Planning Application Ref: FG/150/21/T

Location: 1 Sea Lane Close, Ferring, BN12 5DT

Description of works: Fell 1no. Monterey cypress tree (T1) and fell 1no. Austrian pine tree (T2)

Mark Warwick
Tree Officer / Parks and Greenspace Team

1 Sea Lane Close, Ferring

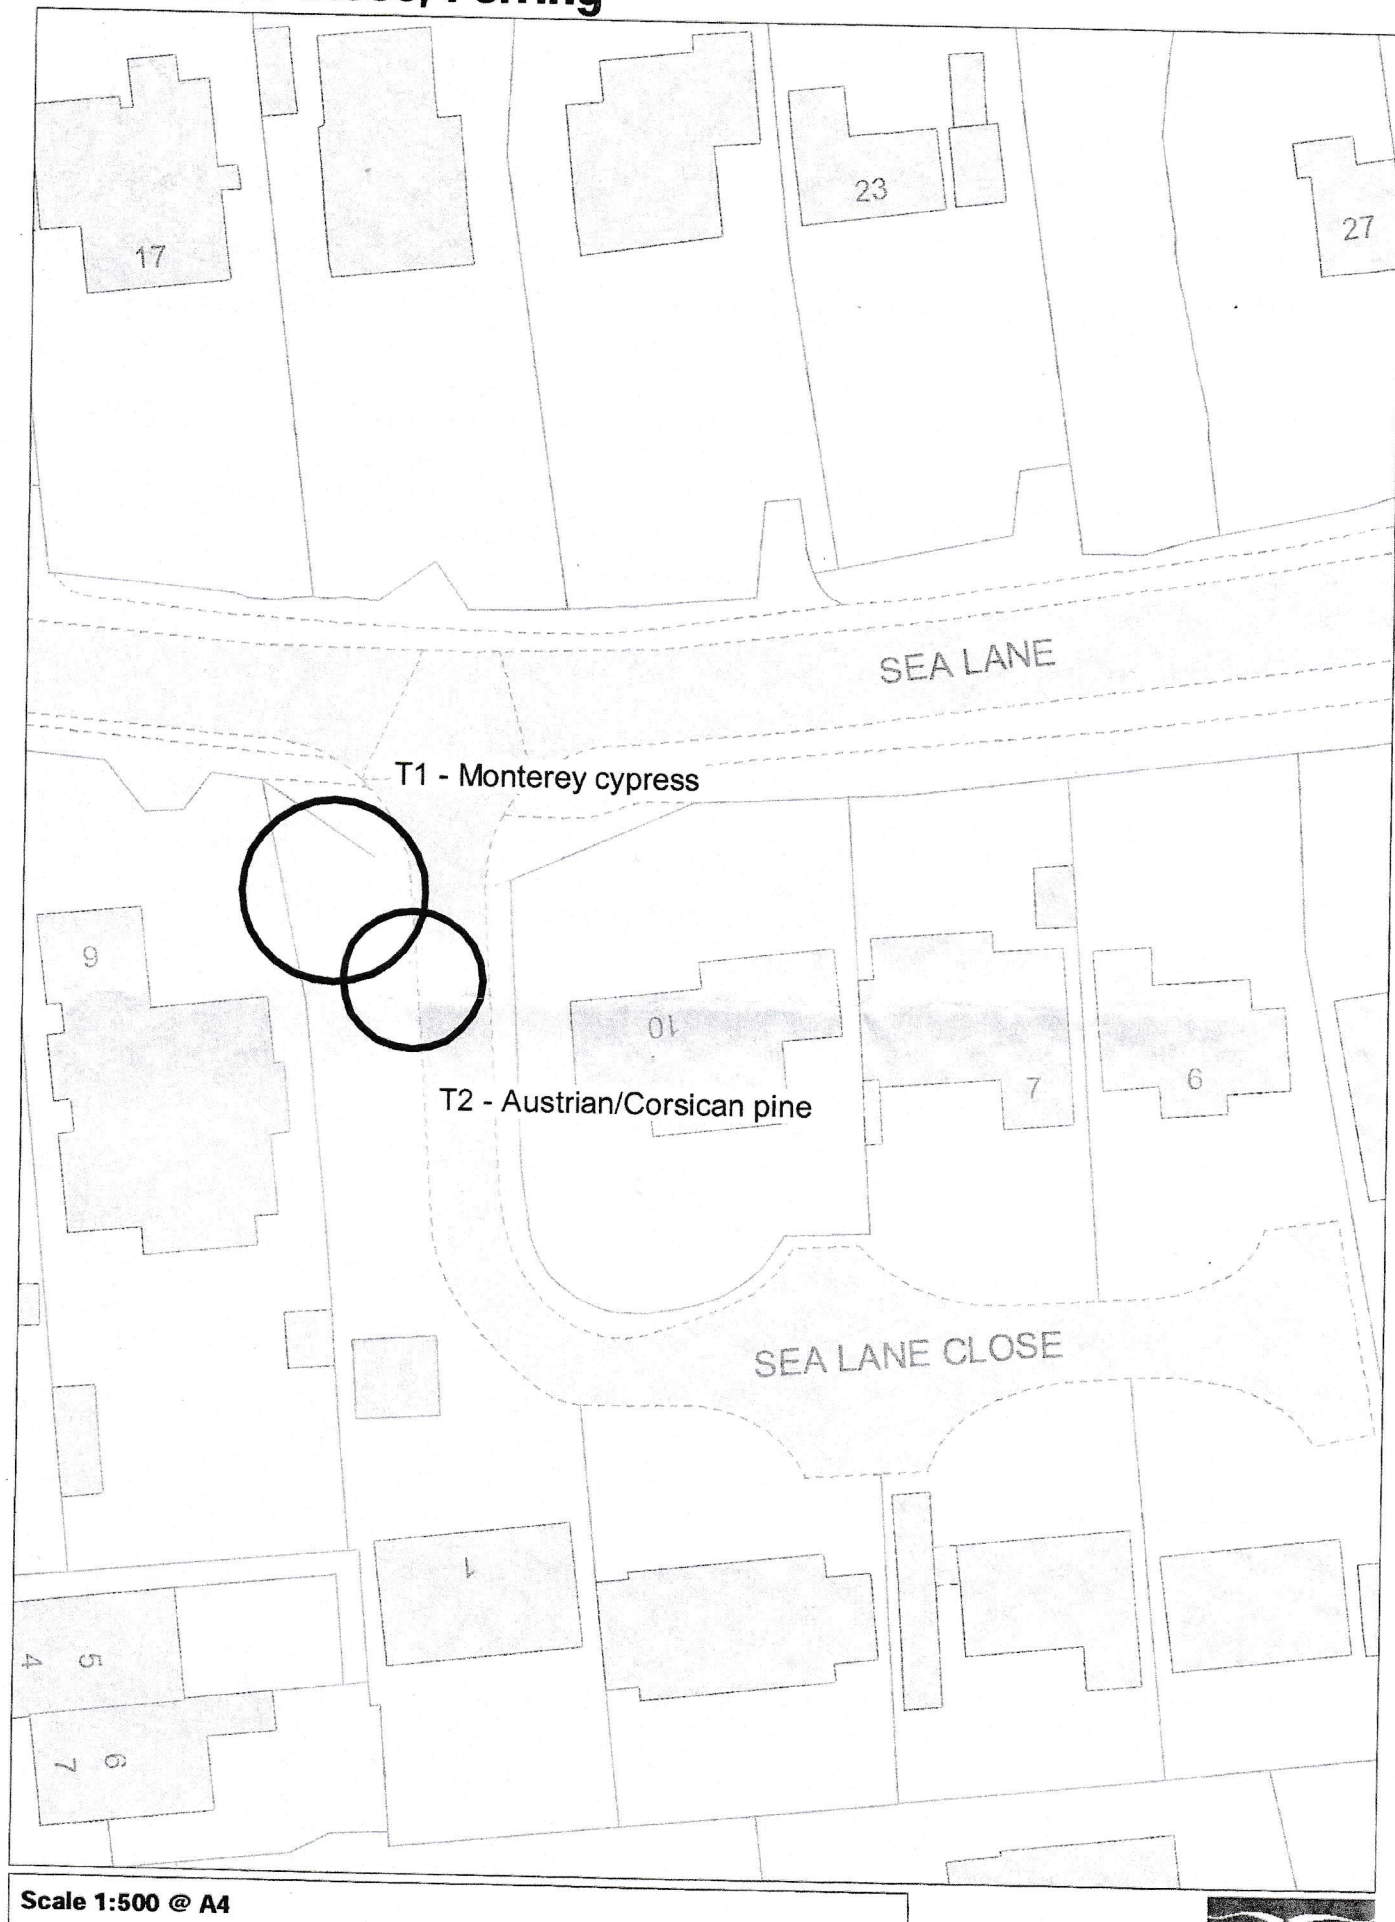
- T2 is the lesser amenity tree and its removal unlikely to be keenly felt by local residents and visitors. It has been implicated as an influence over ground conditions around and below foundation depth in proximity of building damage. On balance, the removal of T2 can be justified on arboricultural grounds if not wholly for the reason given.

- The removal of T1 has not been justified on arboricultural grounds. It is accepted that roots are likely to be within curtilage of 6 Sea Lane Close and influencing ground conditions to some extent, but there is no established relationship between T1 and any damage event. Root morphology can be complex, and trees of high public amenity should not be discarded in the absence of thorough site investigation. The current proposal for T1 seems contrary to the statement made in additional comments at sect.4 of the report '*Engineers should consider focusing investigations to strengthen factual evidence for disclosure to third party tree owners*'.

- As it stands, I recommend **REFUSAL** for this application.
 - **I would like the applicant to be invited to agree to a revised proposal for lesser works** (by excluding the proposal to remove T1) as part of the current application so as not to incur further delay. Such work would go some way to addressing their concerns whilst preventing undue diminution of local landscape and public amenity value.
-
- If the applicant is prepared to re-submit in line with this advice, then I would be able to recommend APPROVAL

T1 - Monterey Cypress (Right) & T2 - Austrian Pine (Left); observed from Sea Lane

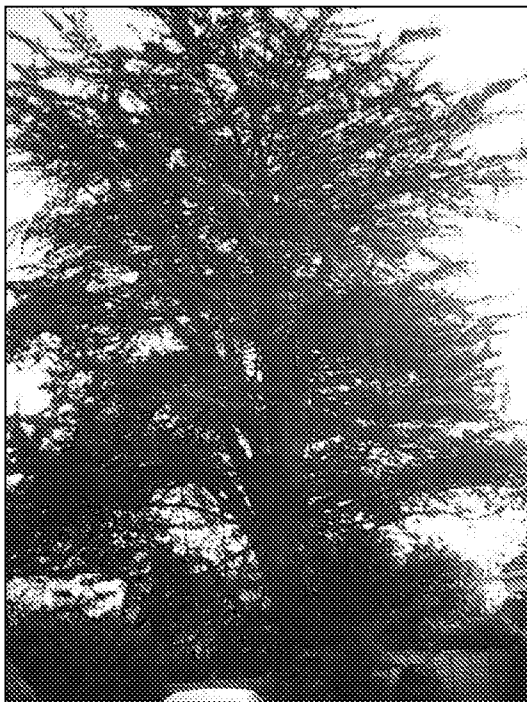
- Outwardly and from a distance (roadside) these trees appear to be in a fair physiological state and assumed to be so in the absence of any evidence provided to the contrary. They are long-established and highly visible to the public; T1 especially so, being very large and prominent adjacent busy highway. T2 is mildly suppressed and concealed by its dominant neighbour.
